Current Zoning: R-8MF(CD) (multifamily residential, conditional)
Proposed Zoning: UR-2(CD) (urban residential, conditional)

Approximately 12.403 acres located on the west side of IBM Drive, south of Baucom Road, and north of University City Boulevard.

The petition proposes a residential community containing a maximum of 200 multi-family dwelling units and any incidental and accessory uses that are allowed in the UR-2 zoning district.

**STAFF
RECOMMENDATION**

RZ-2

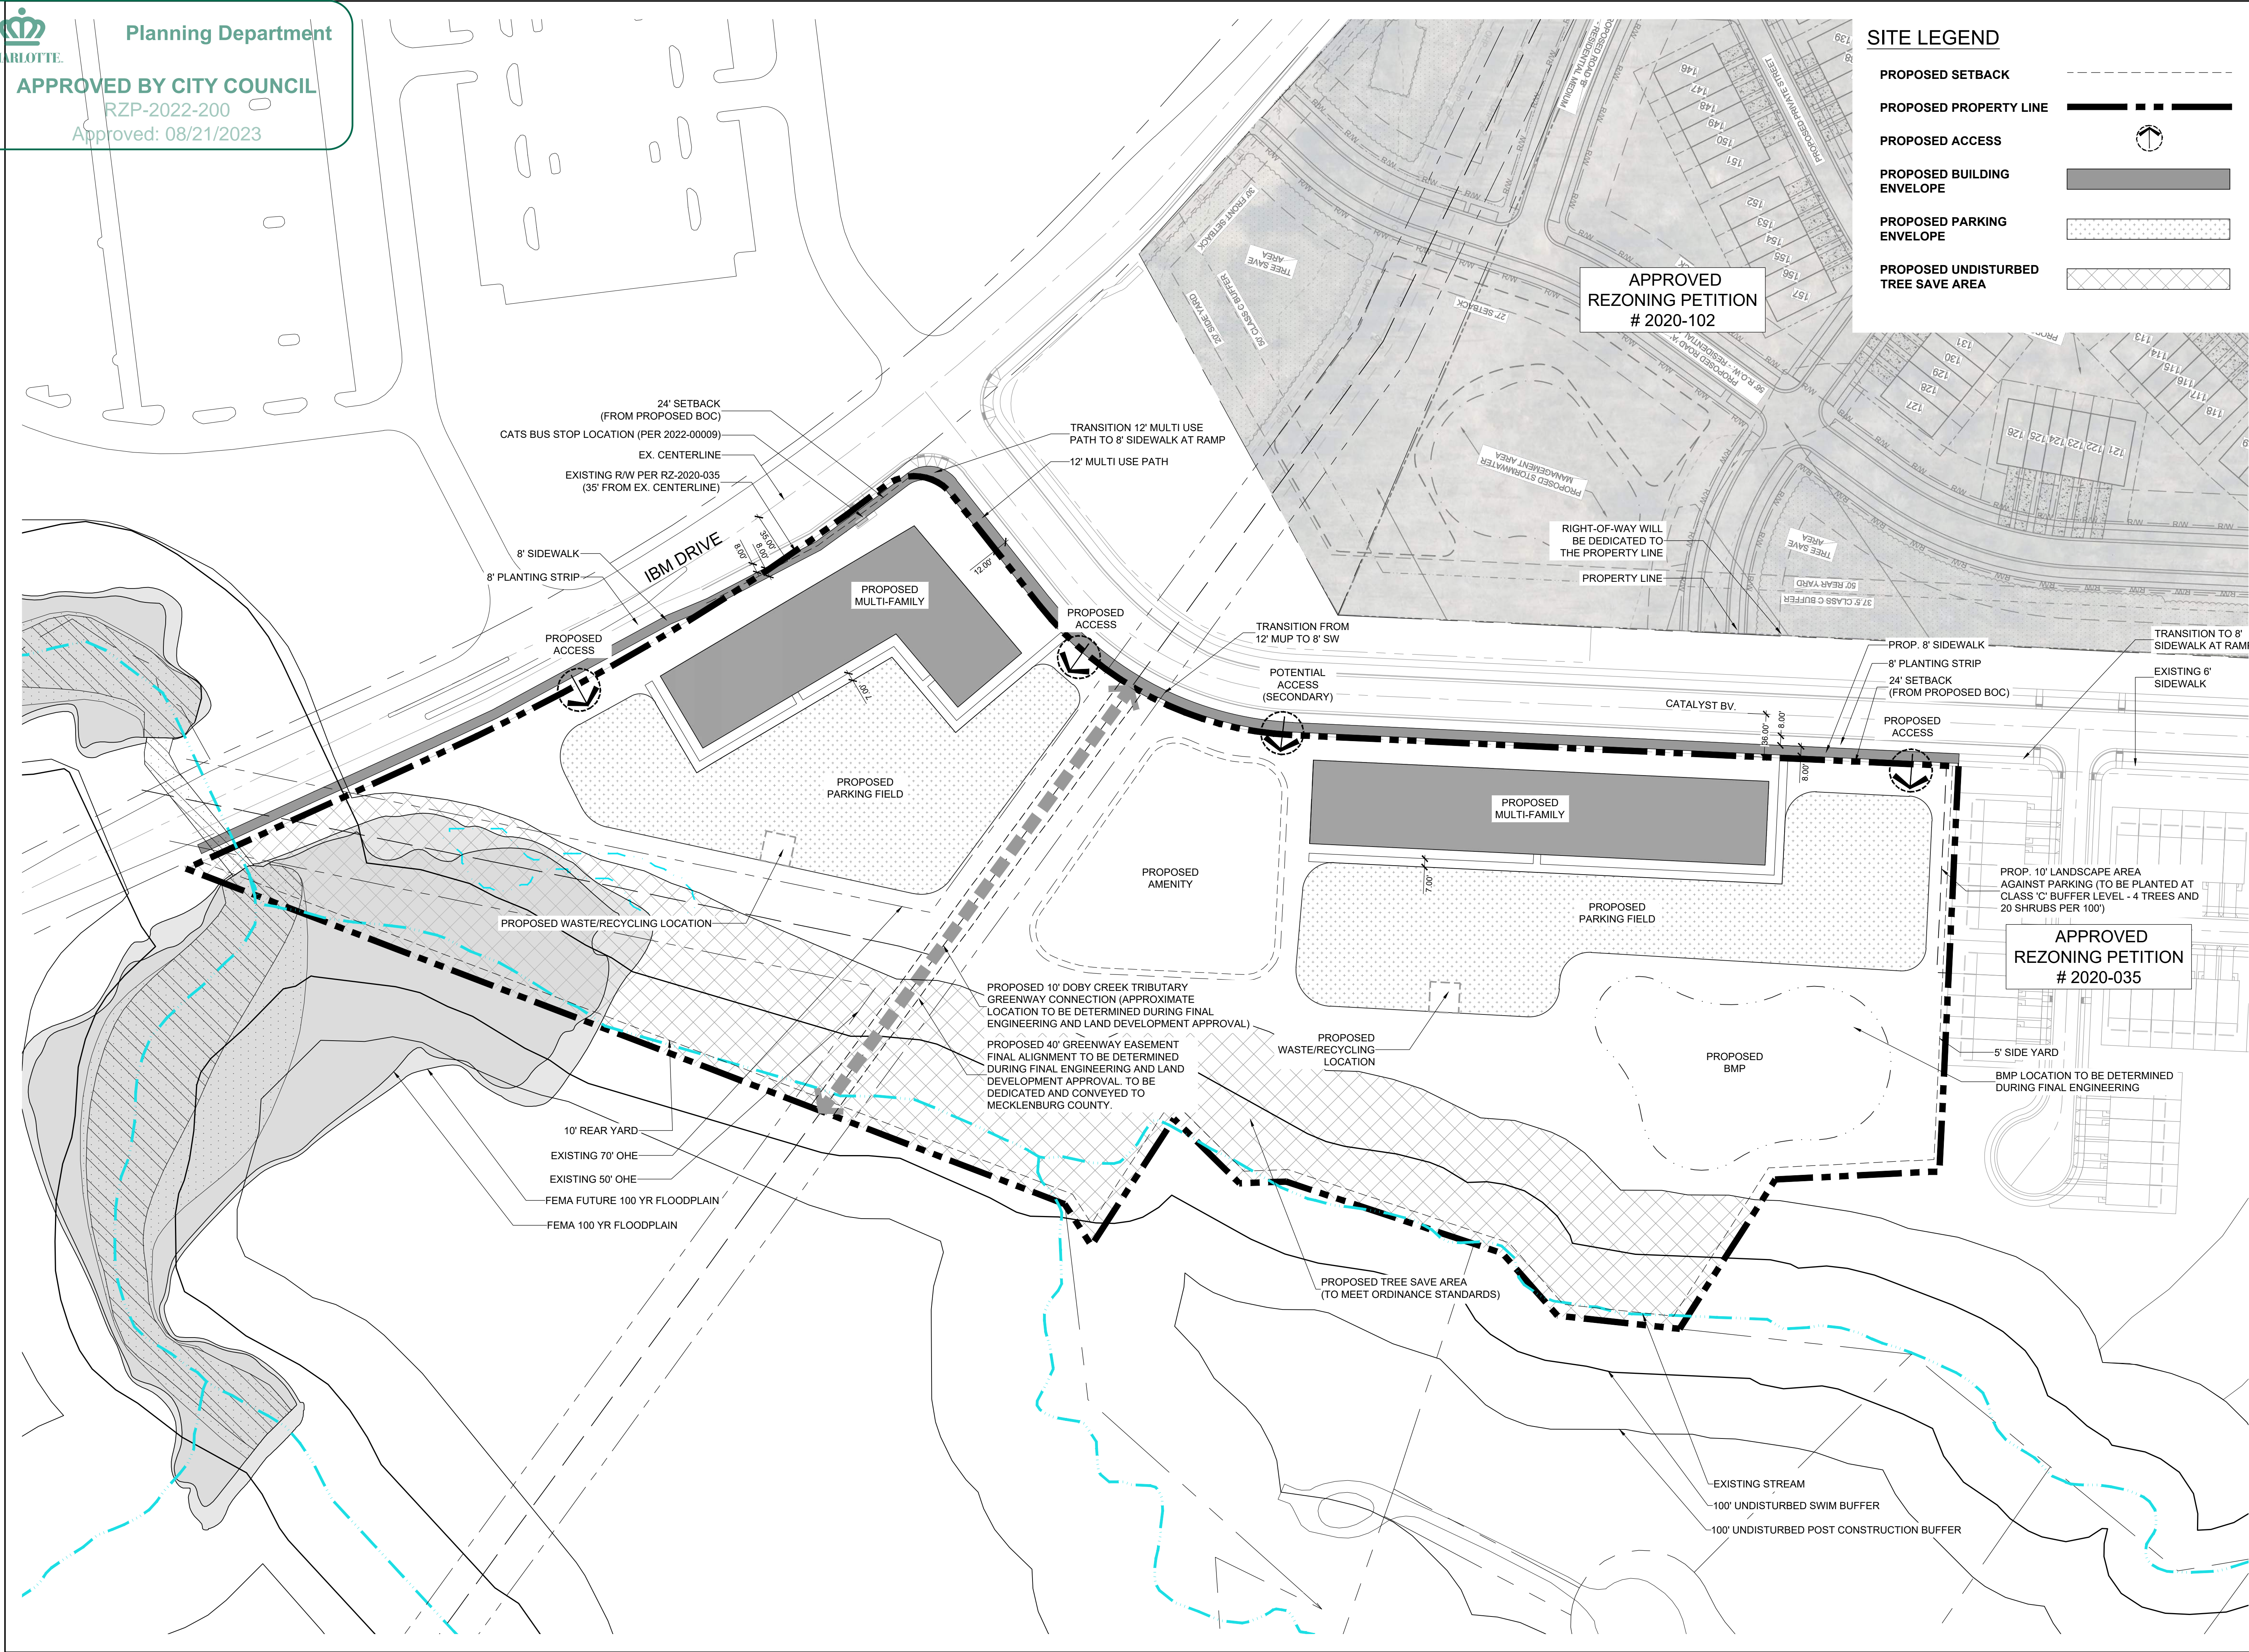
1. Revise site plan and conditional note(s) to commit to revising southern access location to align with the adjacent development access or remove from plan.

2. Plans currently show that the developer will build a 10-foot trail and provide a 20-foot easement between the Catalyst Boulevard multi-use path and Mecklenburg County Property. Mecklenburg County's preference is for the developer to provide a 60-foot easement along this corridor for Mecklenburg County to construct the trail in the future. If the developer still wants to construct the trail and dedicate the trail to Mecklenburg County, the trail should be constructed to County standards at 12-foot width with a minimum permanent easement of 22-foot along the constructed trail.
3. Show tree save area on plans.
